From: dc.support@cherwell-dc.gov.uk
Sent: 06 April 2021 11:12
To: DC Support
Subject: New comments for application 20/00964/OUT

New comments have been received for application 20/00964/OUT at site address: The Beeches Heyford Road
Steeple Aston
OX25 4SN

JOB TITLE The Beeches, Steeple Aston		CLIENT Framptons	
DRAWING TITLE Proposed Site Access Vehicle Tracking & Visibility Splays			
SCALE As Shown	DRAWN BY BP	DATE May 19	DRAWING No 20388-02
REVISION B

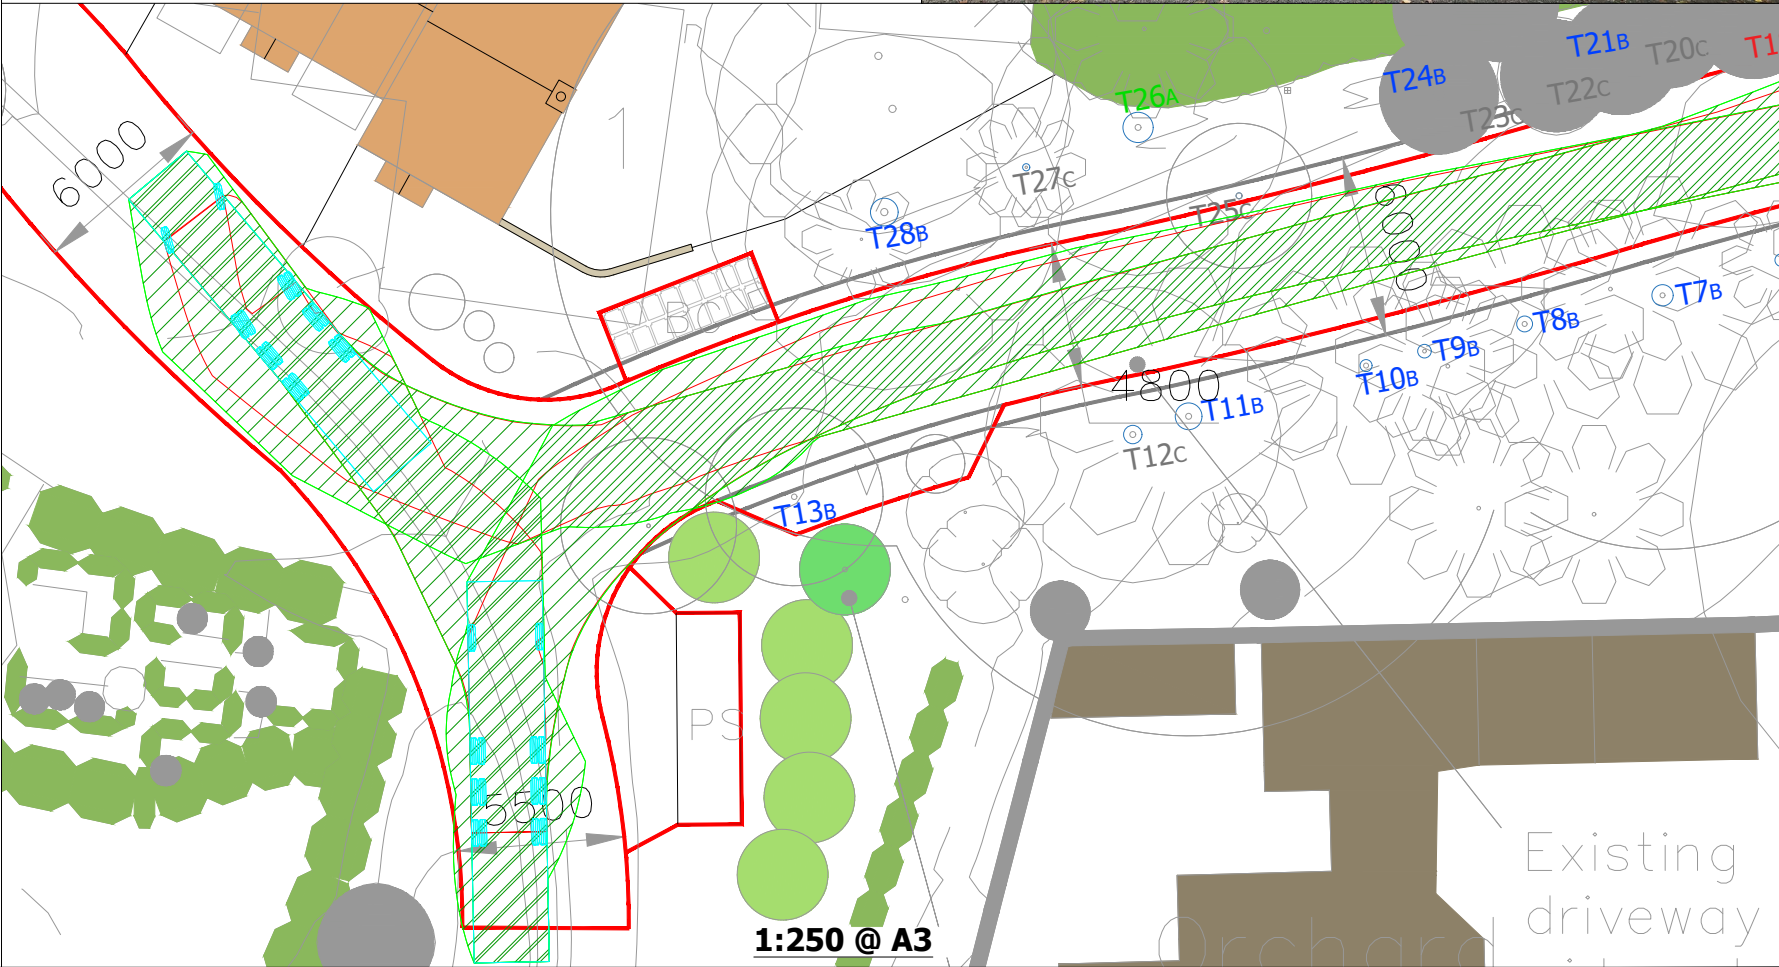
Can anyone explain how the driveway from 8 large houses with i assume at least 2 cars is going to work? Also when the building work starts there is going to be alot of noise and pollution ,how is this going to be for me as a direct neighbour and the village?
